KITITITAS COUNTY

DEPARTMENT OF PUBLIC WORKS

MEMORANDUM

TO: All Staff
FROM: Public Works Planning Review Team
DATE: December 2, 2020
SUBJECT: VA-20-00012 Moore

SITE PLAN

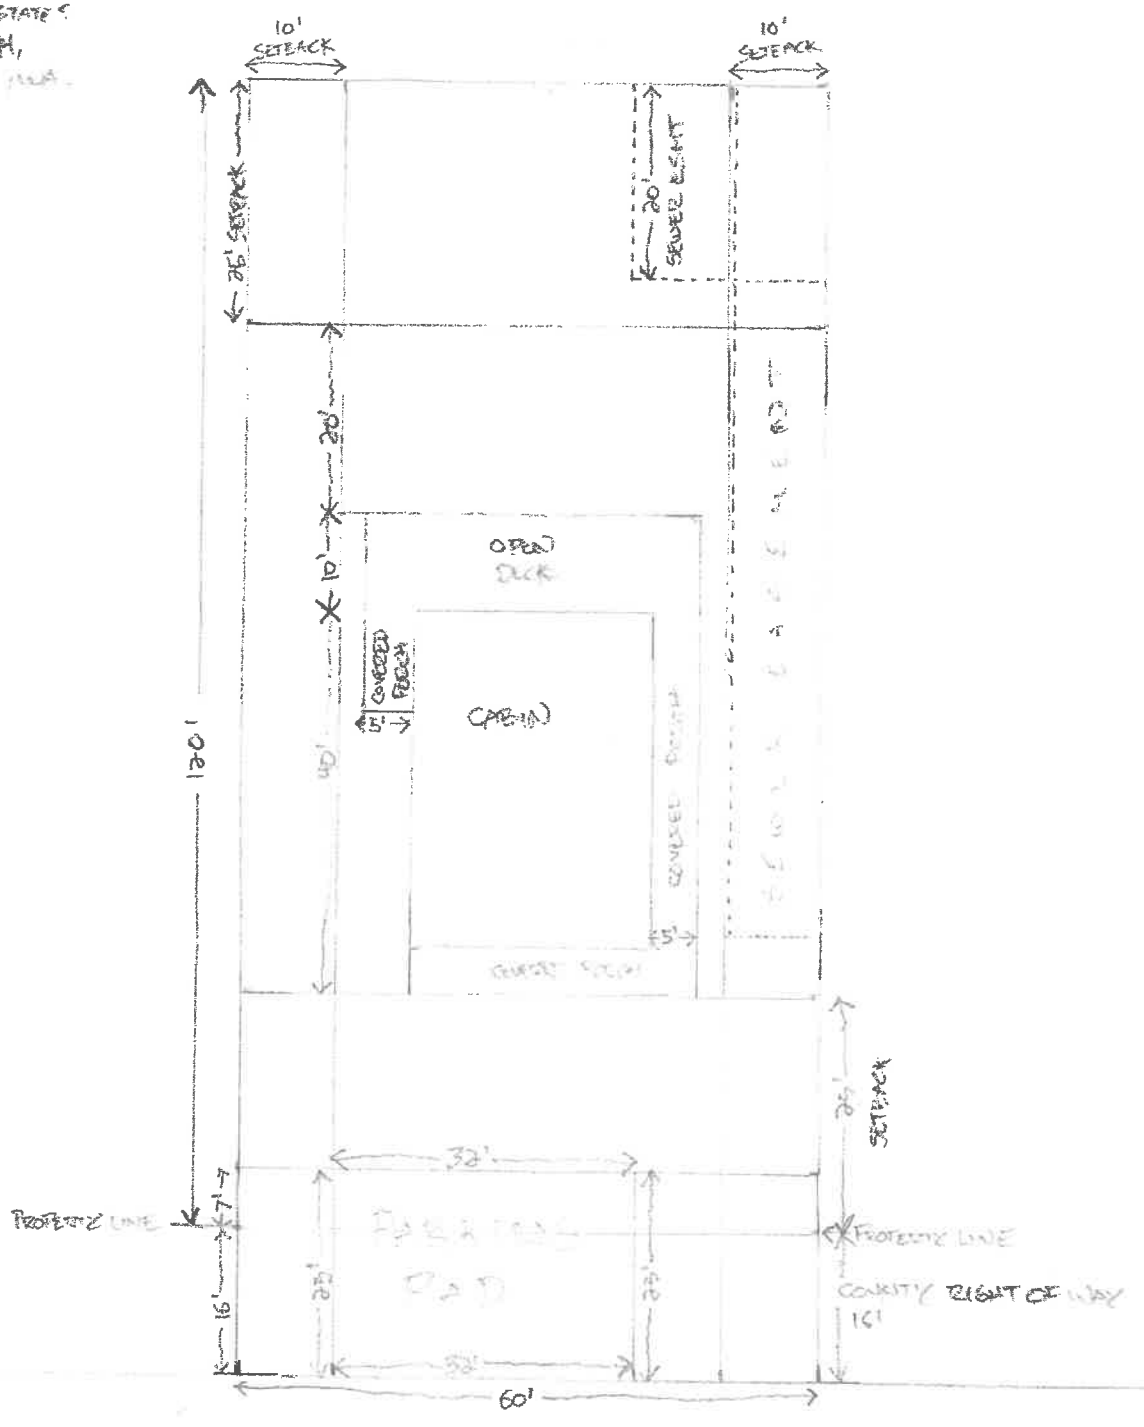
- E. Please provide engineered drawings of the parking pad which have been reviewed and stamped by a professional engineer. The drawings should contain materials used, slope of the parking pad, contours of the proposed structure and surrounding area, and any other information important to the design.

- F. Please provide documents which verify drainage on the parking pad and neighboring properties dealt with. Please see the Eastern Washington Stormwater Manual for more information.

- G. Please provide a barrier on the parking pad to protect vehicles and pedestrians from the steep drop offs.
